**Consultation Response from KC,
Lead Local Flood Authority**

2024/92806 Land at, Penistone Road, Fenay Bridge, Huddersfield, HD8 0AW

Discharge of details reserved by conditions 20 (surface water discharge), 21 (flood routeing) and 31 (grass-crete and batter maintenance) of previous permission 2022/93154 for erection of 68 dwellings with associated access, parking, open space, landscaping and infrastructure works (including installation of surface water attenuation tank)

Date Responded: 25th October 2024

TITLE
DETAILS OF ATTENUATION/STORAGE
TANK DETAILS USING POLYSTORM
PSM1A UNIT.

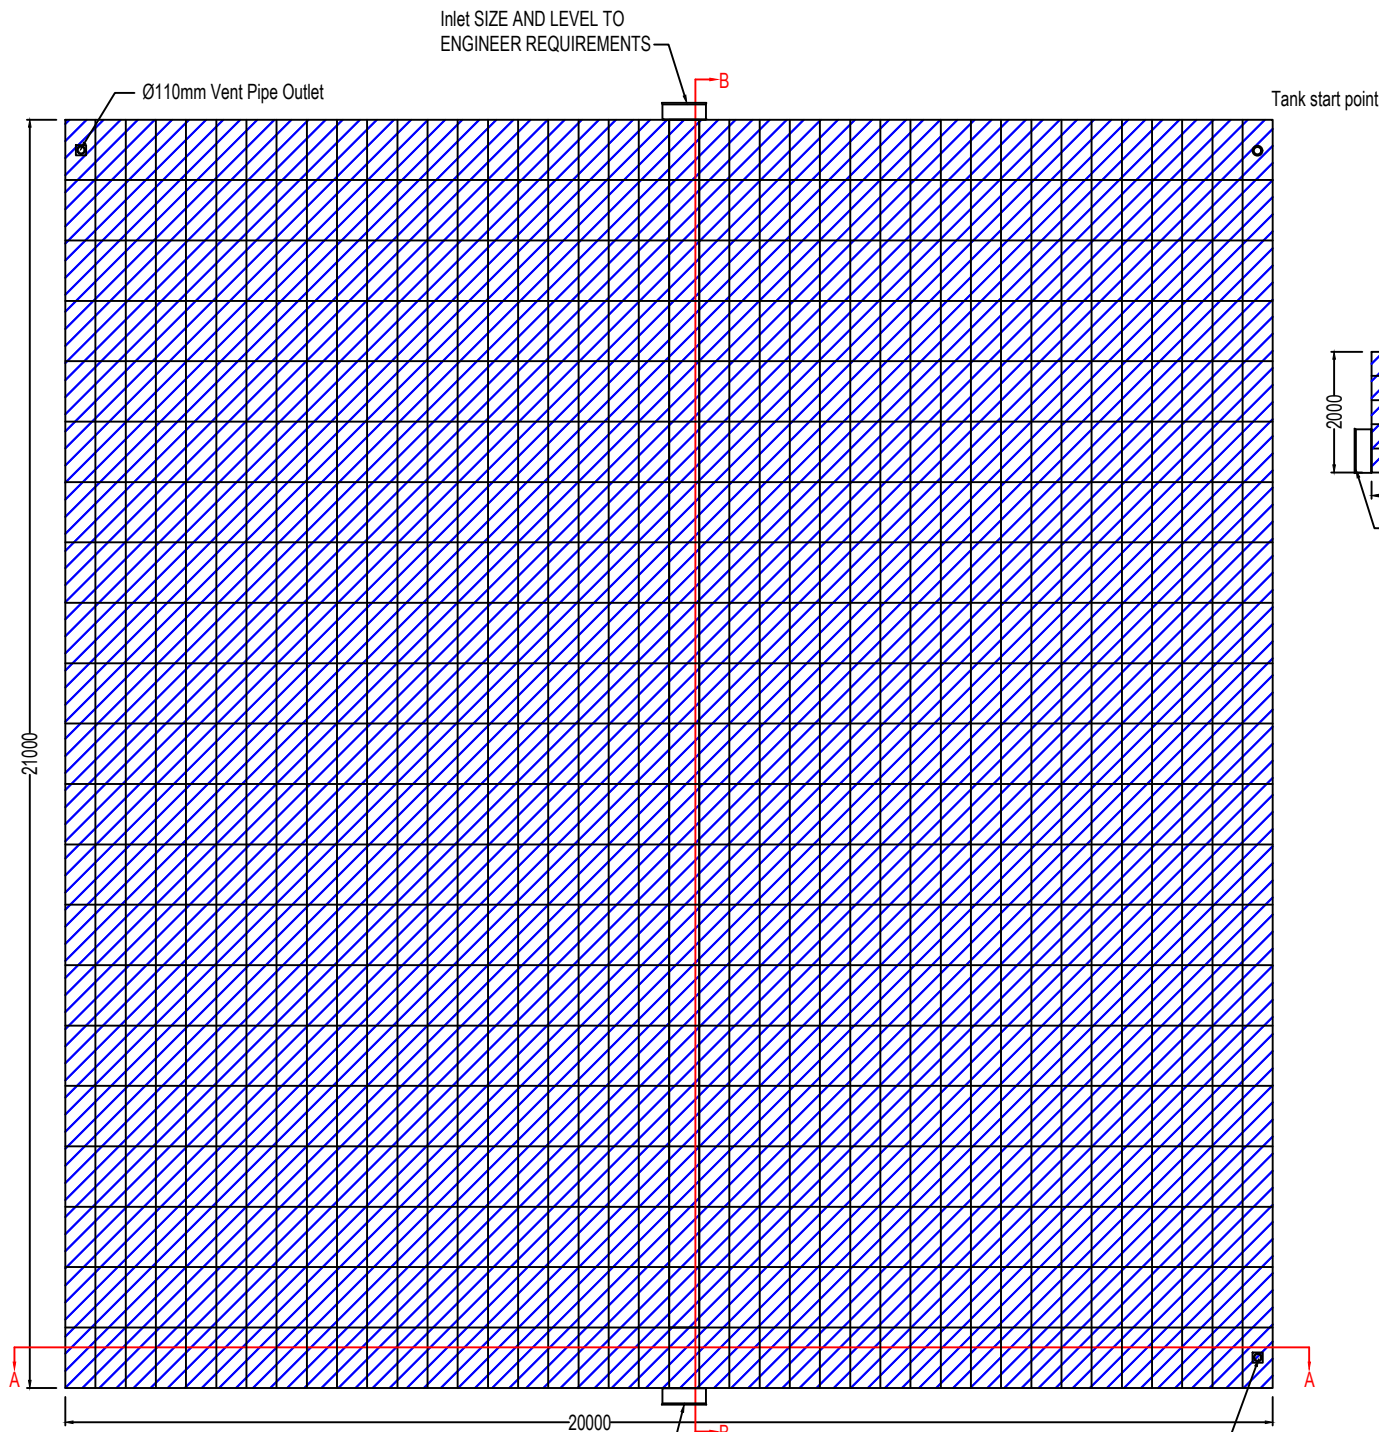
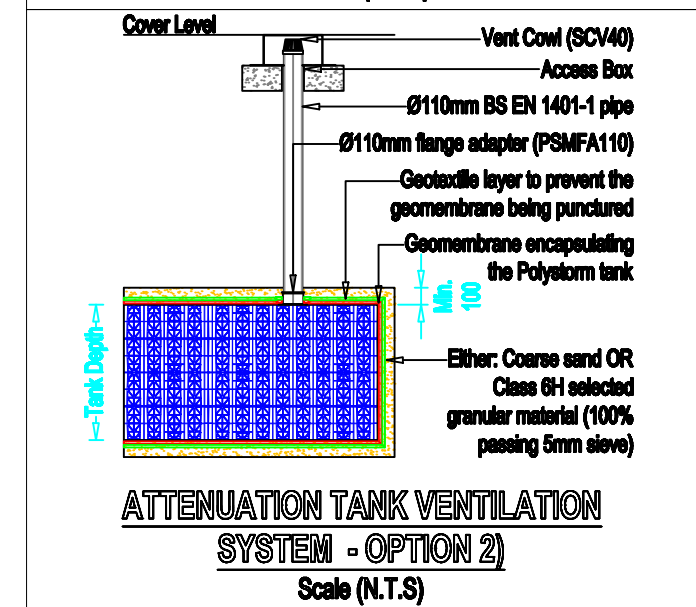
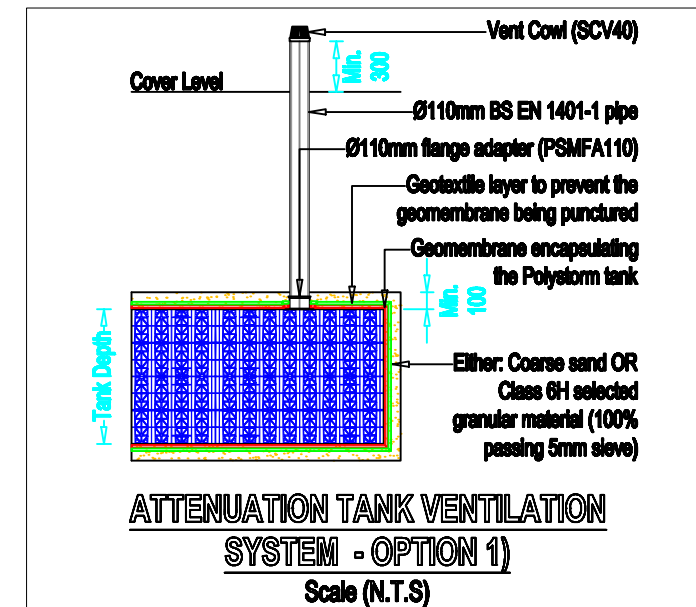
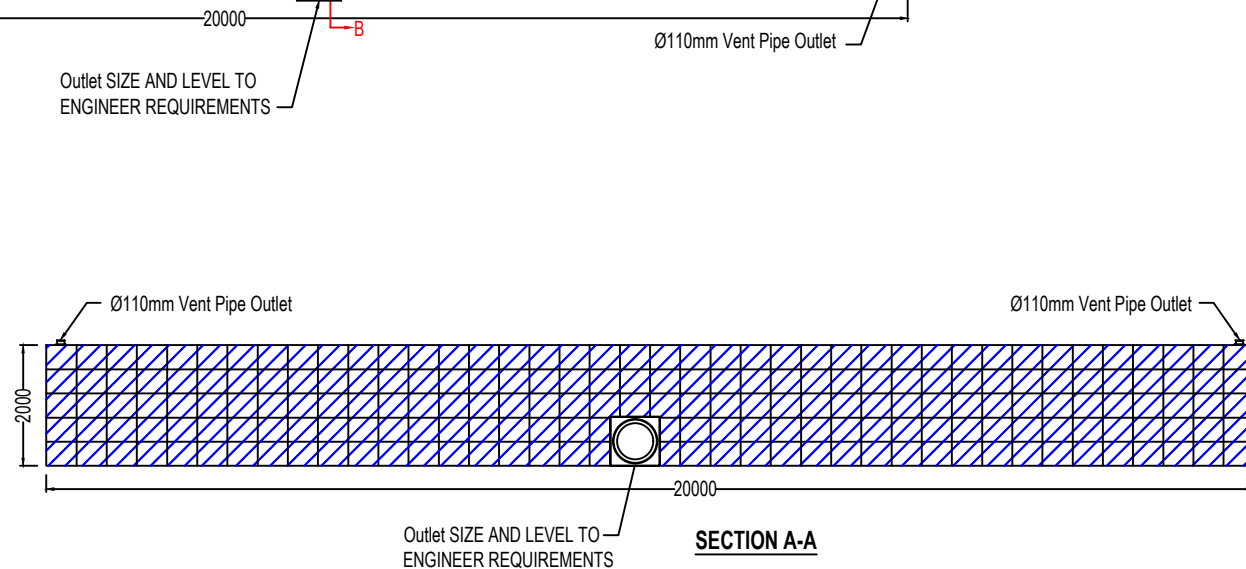
Details of a Carlow Tank and a Crate Storage alternative has been submitted. Its is therefore not clear what is being promoted here. A surface water drainage layout plan will also be required as will a coloured impermeable area plan showing which areas of hardstanding are contributing to specific receiving legs of sewer. This must correspond with the design and simulation model. A maintenance and management plan for the selected attenuation design is also required. This must be specific to the site and include access to and into the tank

We advise the planning officer not to accept crate storage on residential applications given the lack of guarantees on lifespan and difficulty if not impossibility to survey to installed tank. The LPA has an obligation to ensure the effective maintenance and management of SUDS features.

Only if a statutory undertaker (Yorkshire Water or a NAV equivalent) produced a technical approval letter under section 104 Water Industry Act 1991, to agree to adopt such a system would we advise to proceed.

We do not recommend that this condition be discharged at this moment in time.

Drawing Title
Attenuation Tank Drawing

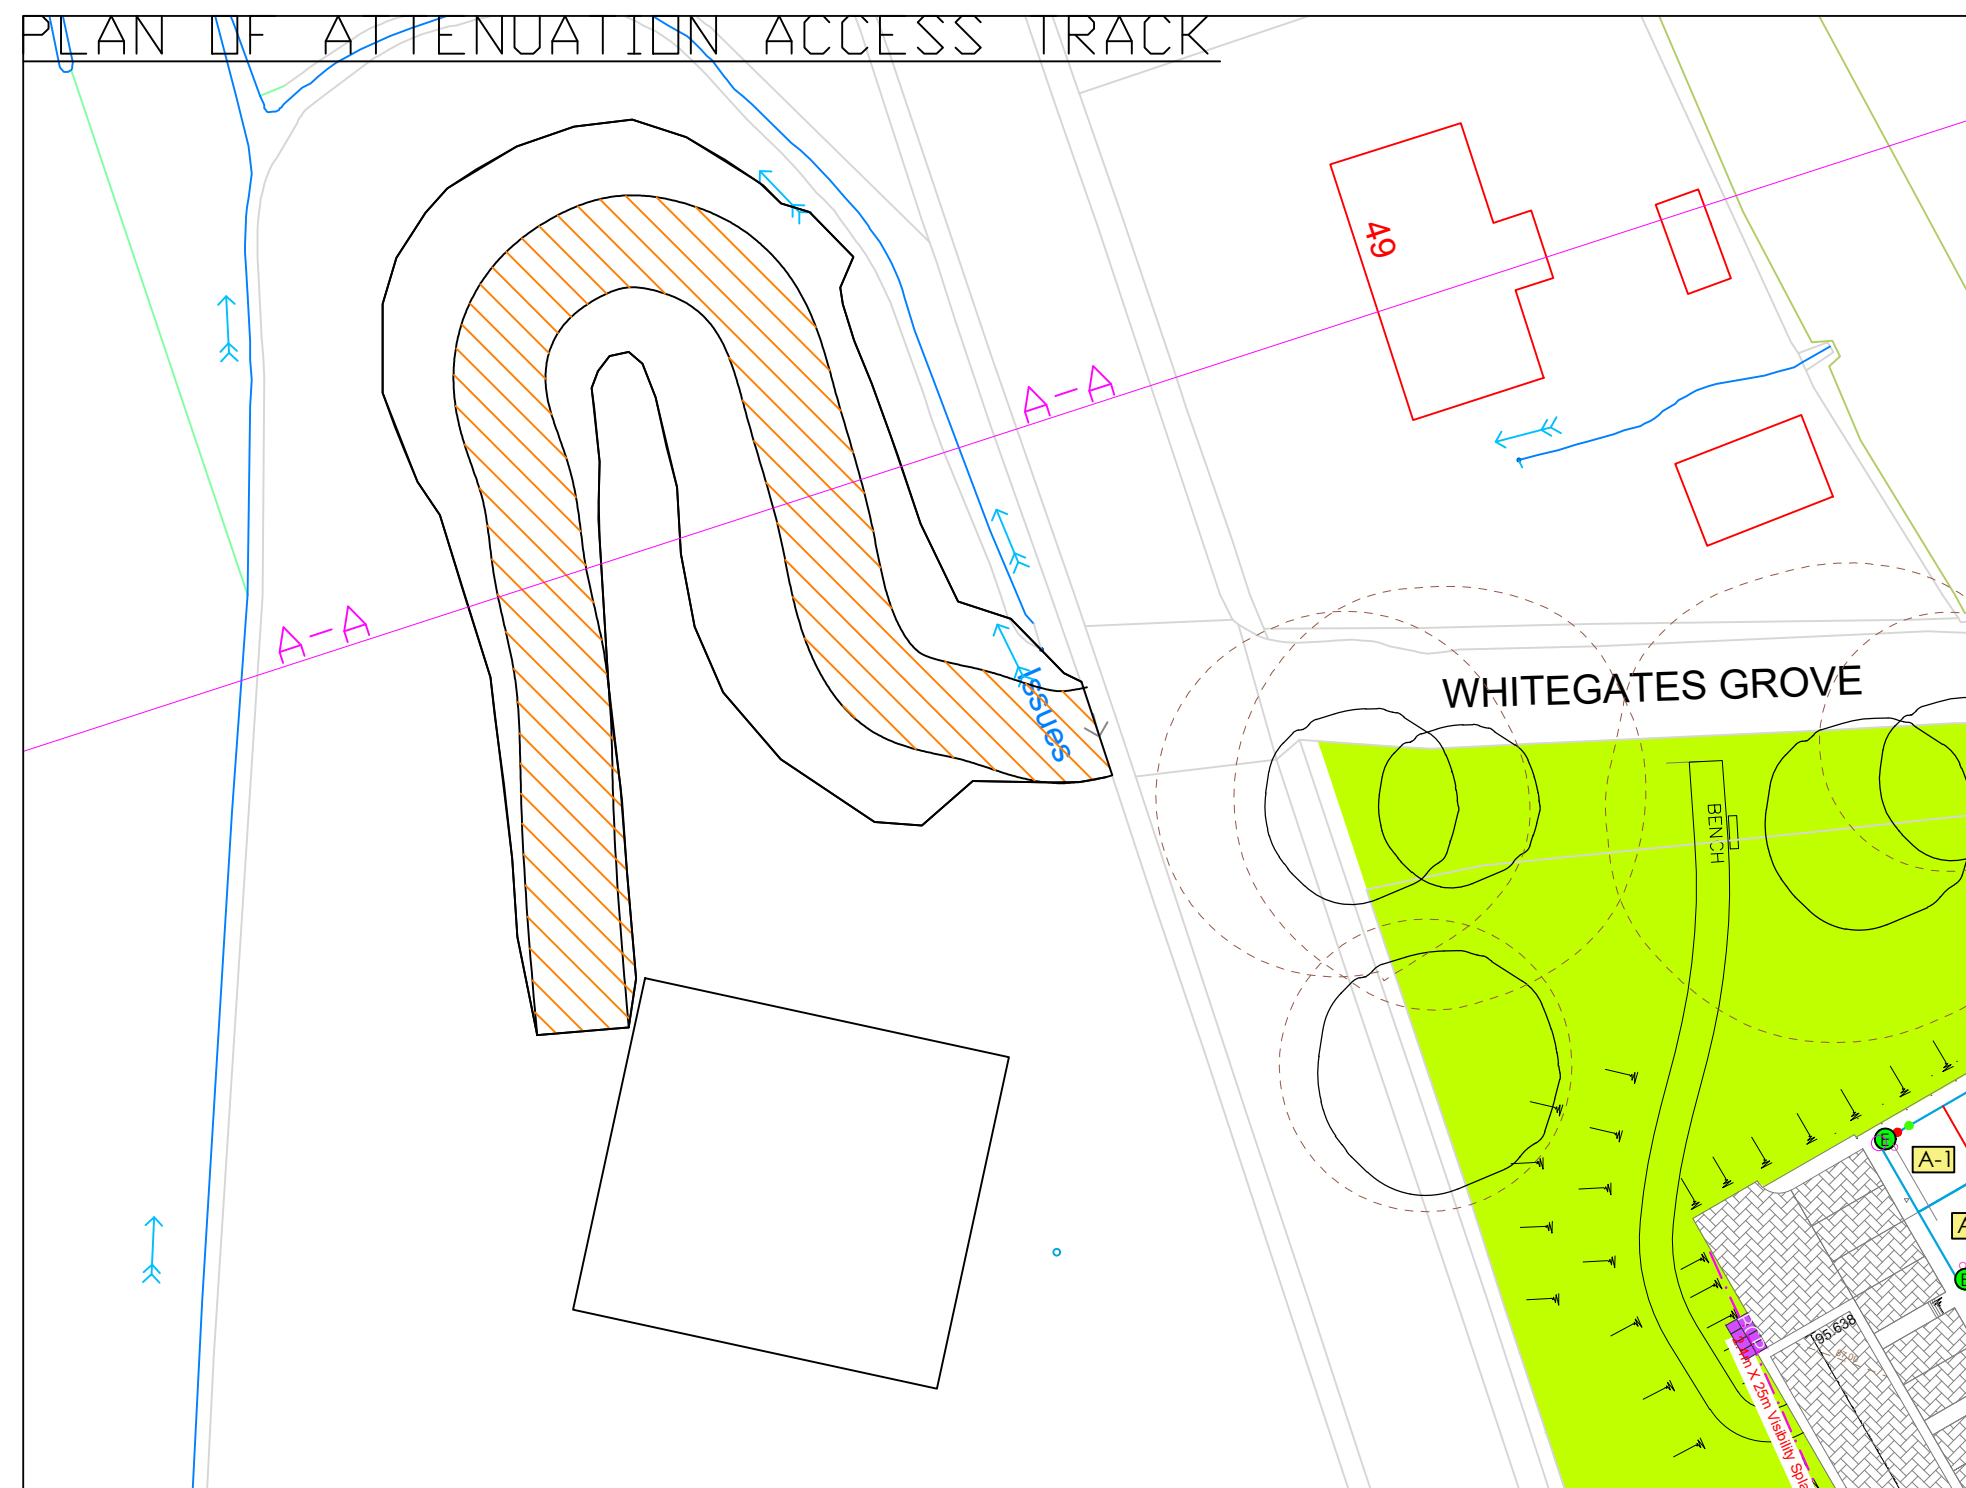
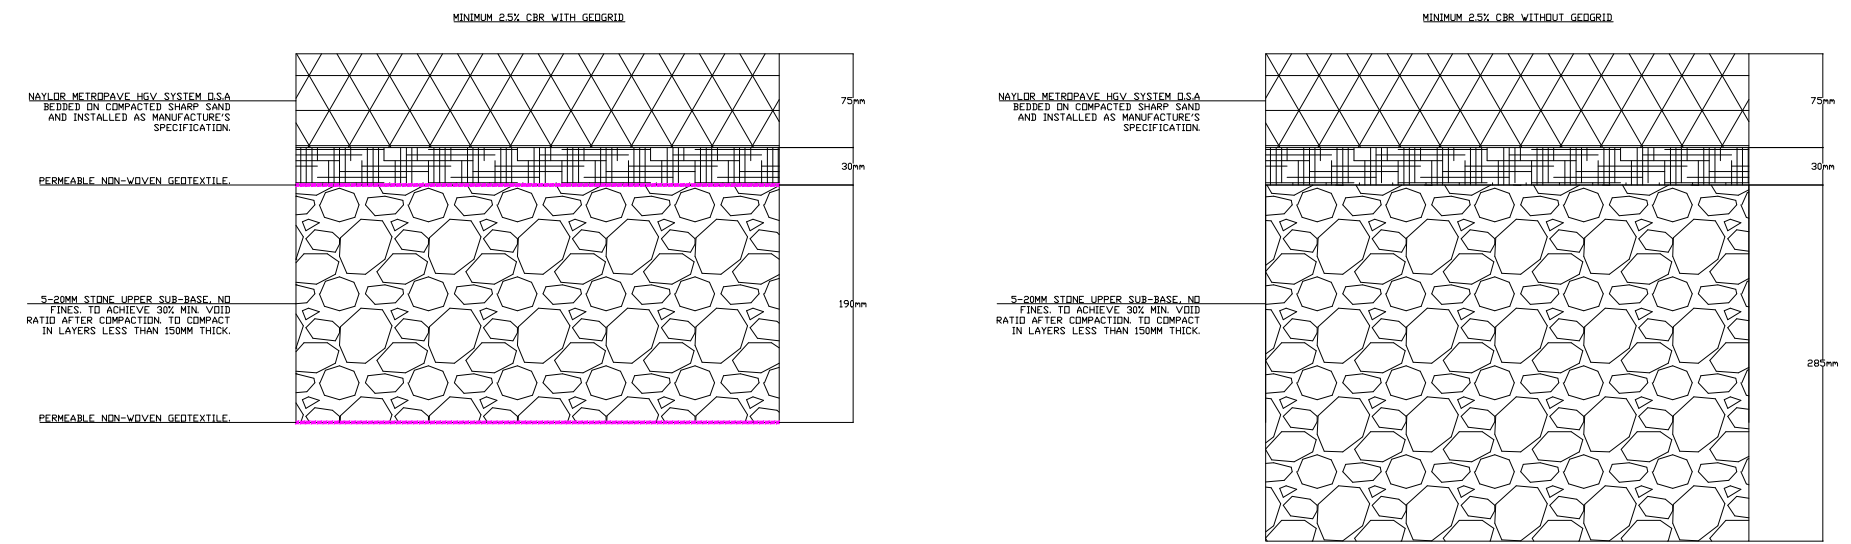
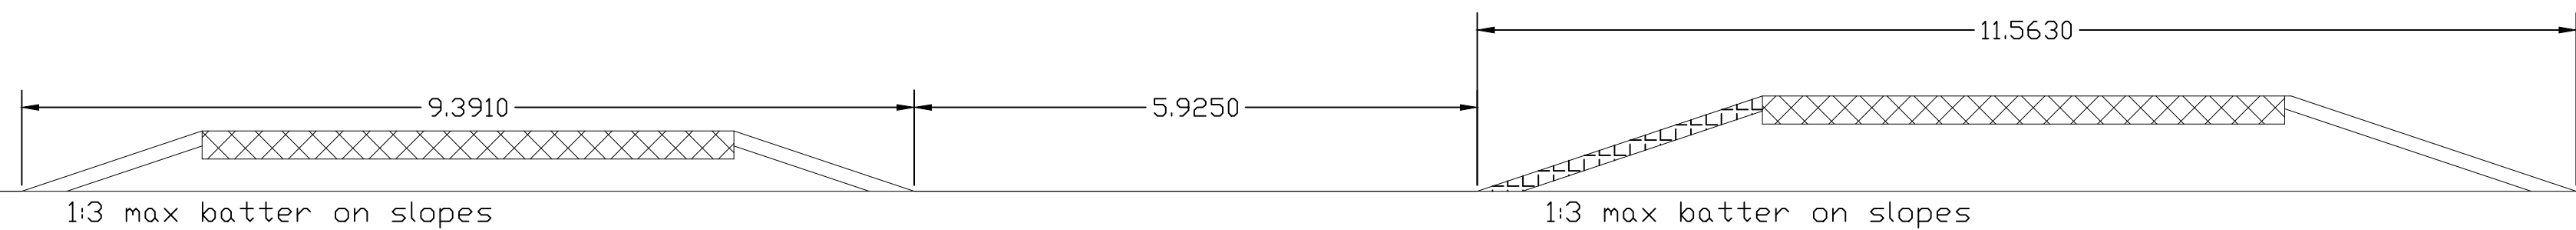
The LLFA did not set this condition and would take advise the planning officer consults Highways DC/Structures on this matter. The LLFA has no objection in terms of drainage principles.
